STATEMENT OF RESPONSE TO AN BORD PLEANÁLA OPINION

PROPOSED SHD RESIDENTIAL DEVELOPMENT AT FORMER GALLAHERS SITE, AIRTON ROAD

GREENLEAF HOMES LIMITED

February 2020

GROUND FLOOR LEVEL
PROPOSED ACCESS AND CIRCULATION

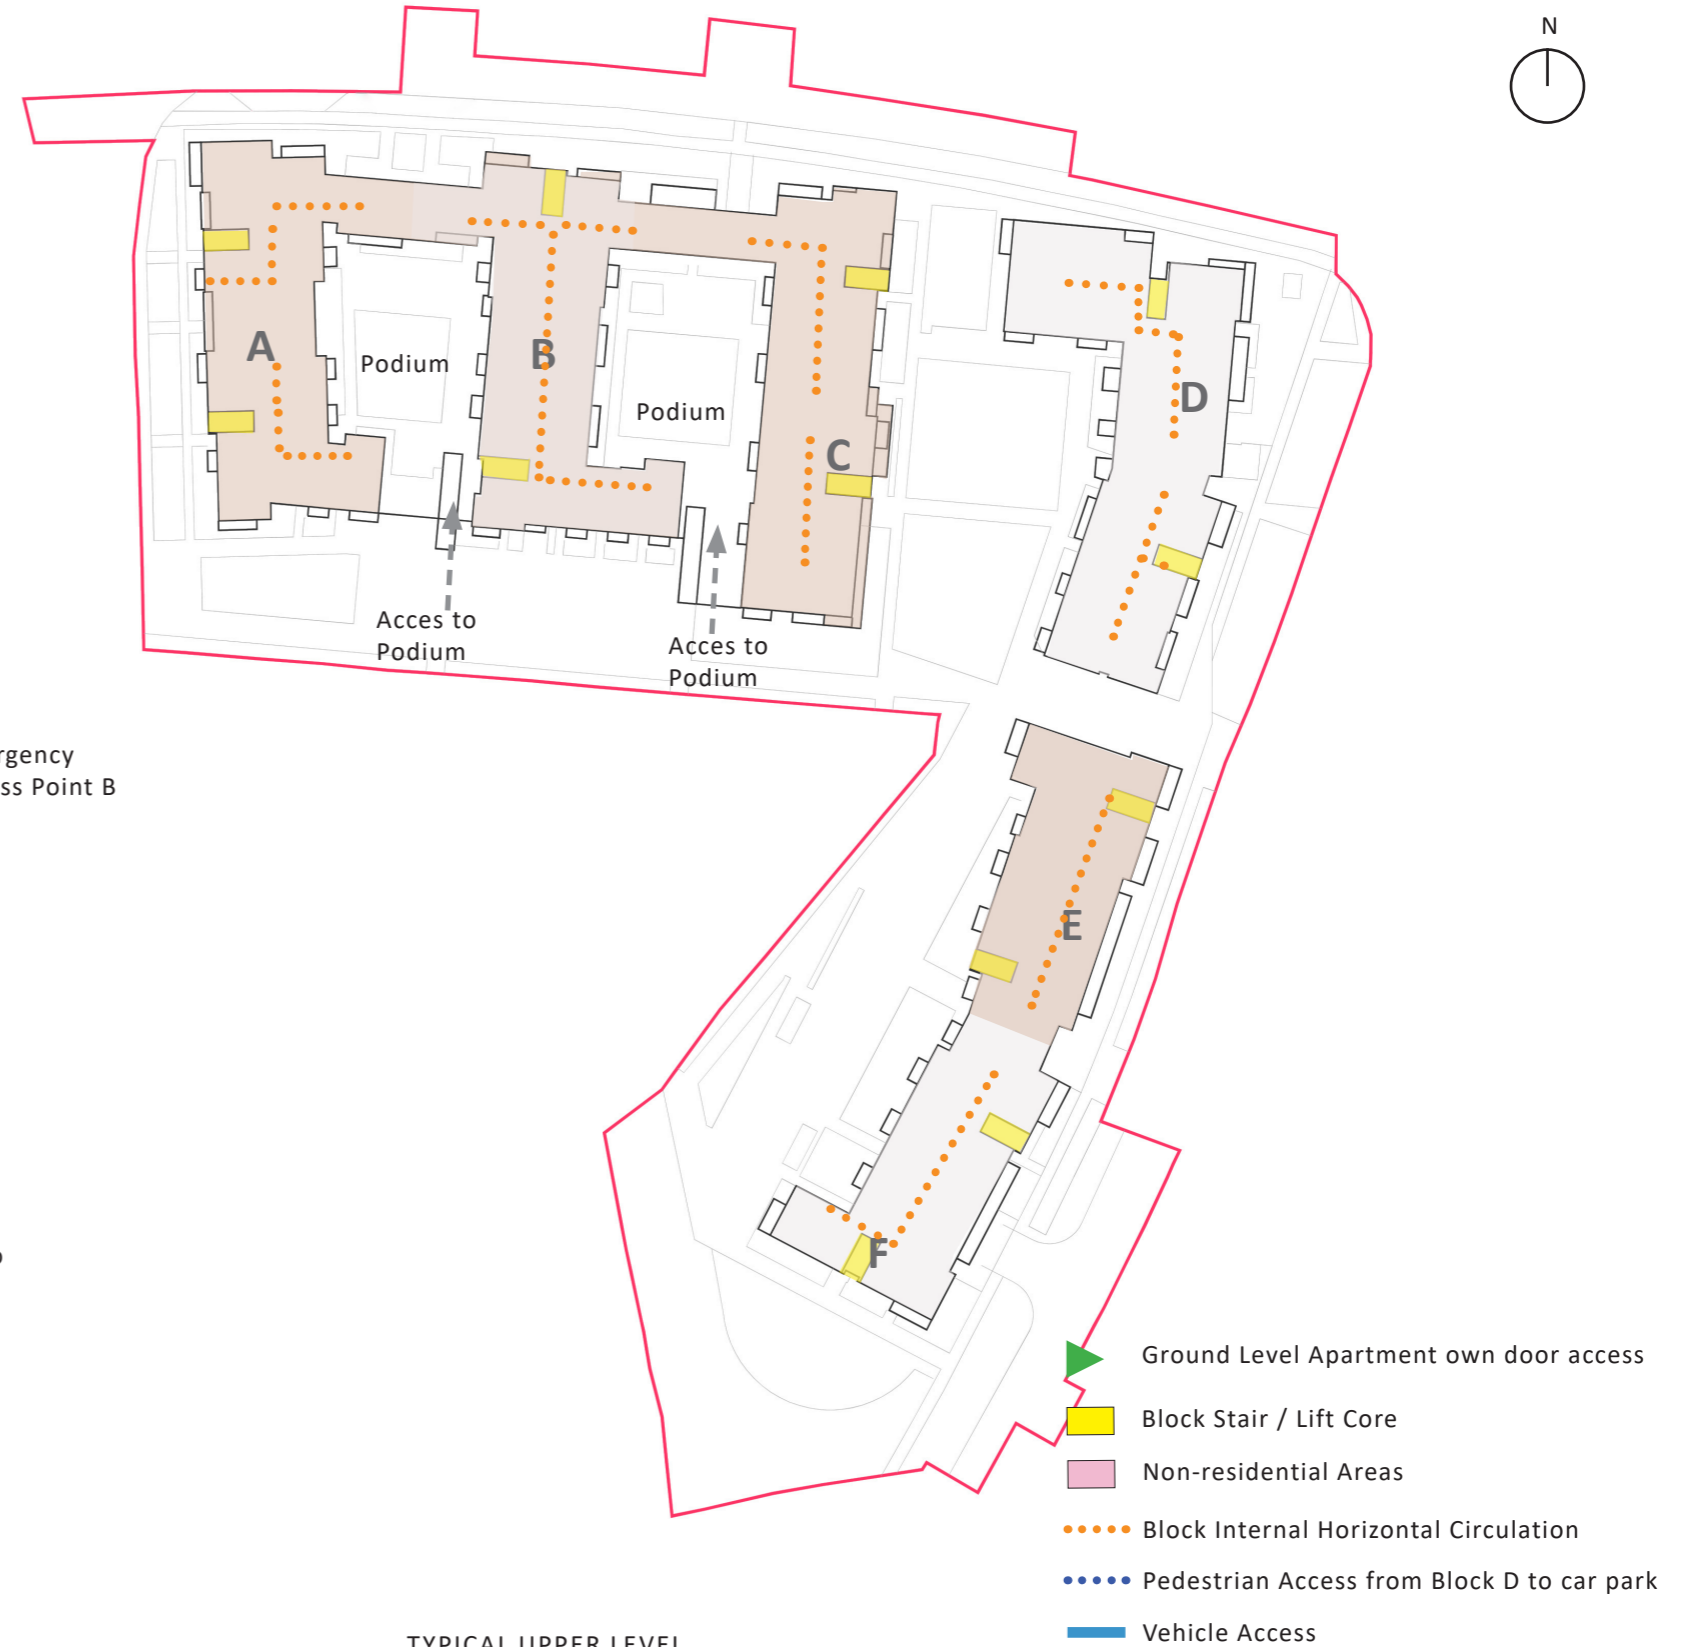
- (ii) Further consideration and/or justification of the documents as they relate to the ground floor uses of the proposed scheme, in particular along Greenhills Road, Airton Road and surrounding the 'Courtyard Open Space' in terms of the creation of an active and vibrant streetscape at this location. A Design Statement addressing the criteria contained within section 11.2.4 of the South Dublin County Development Plan 2016 in relation to development within such regeneration zones should be submitted.

The proposed development has re-examined the location of the retail units and the creche and how they interact with both the Greenhills Road, Airton Road and the main public open space within the heart of the development. The revised layout provides for the creche and also some interesting open spaces along the internal route which would become a street through the development in any future scheme.

Along Airton Road and Greenhills Road a strong urban edge is provided with commercial elements at the ground floor level. These commercial units complement the existing commercial development in the area while also providing activity in these areas. Units along Greenhills road at ground floor level in Blocks D and E-F have included own door access units. This improves the street animation and interface contributing to passive surveillance of the street. It is envisaged that the relationship with the ground floor of the corner unit, the open courtyard and the creche will have a key relationship in creating activity within this space enabling a safe largely car free area for children to play in and adults to enjoy within an otherwise urban area. In blocks E and F, the car parking has been moved into a basement car park rather than in an undercroft parking area. This creates more visibility and flow between the areas, enhances the open space to the south and generally creates more of a draw through the site. This is in line with the current Regen zoning for the site.

PROPOSED EAST ELEVATION BLOCK D

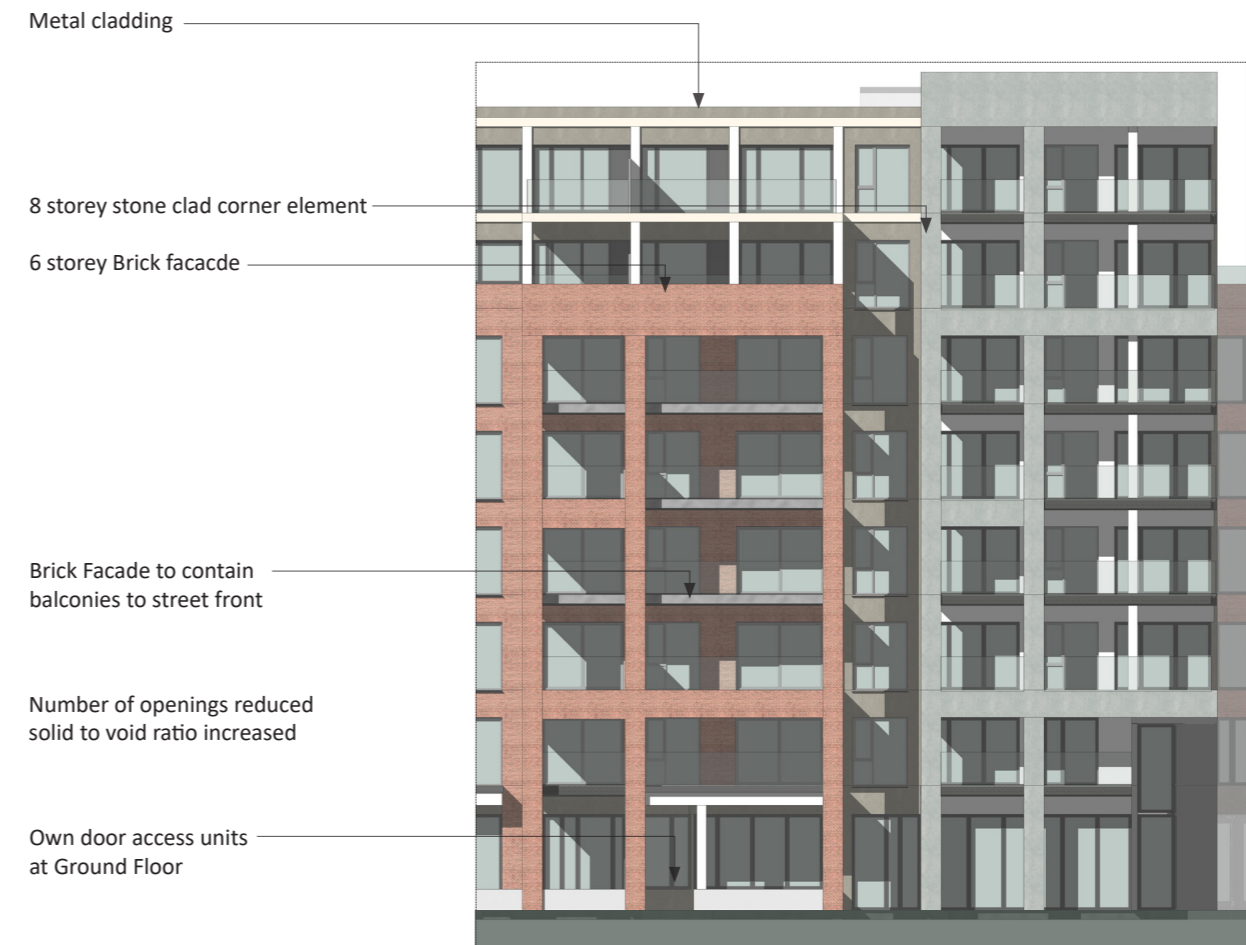
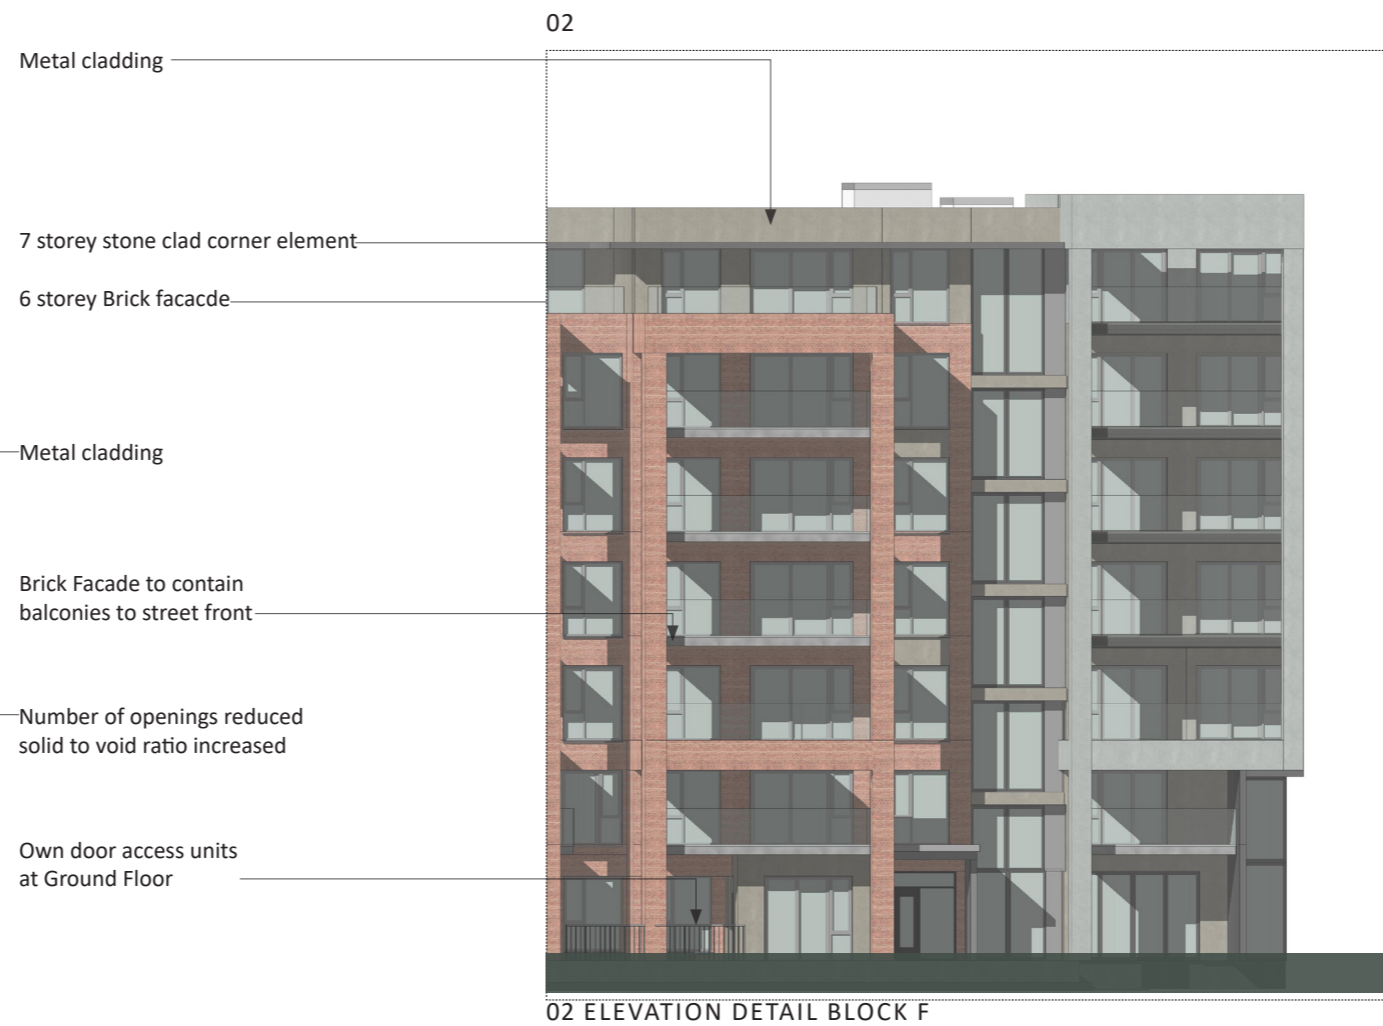
- (i) Further consideration of the documents as they relate to the detailed design of the proposed development. The documentation submitted at application stage should demonstrate that the elevational treatments, external finishes, materials and detailing of the proposed buildings, together with the landscaping and surface/boundary treatments of the outdoor spaces would be of a sufficient quality to ensure that the proposed development makes a positive contribution to the character of the area over the long term. The interface between the proposed blocks and the public realm should also be addressed.

The proposed elevational treatment has been significantly modified from documentation submitted as part of the Section 5 Consultation.

Accordingly, the proposed development will be finished with high quality durable materials that will provide an attractive finish to the development. The proposed finishes on the buildings are complemented by the landscaping and surface/ boundary treatments. The relationship between each block and the proposed and existing public realm along Airton Road and Greenhills Road, including how it may change as a result of Bus Connects proposals along with the proposed masterplan have been carefully considered within the application.
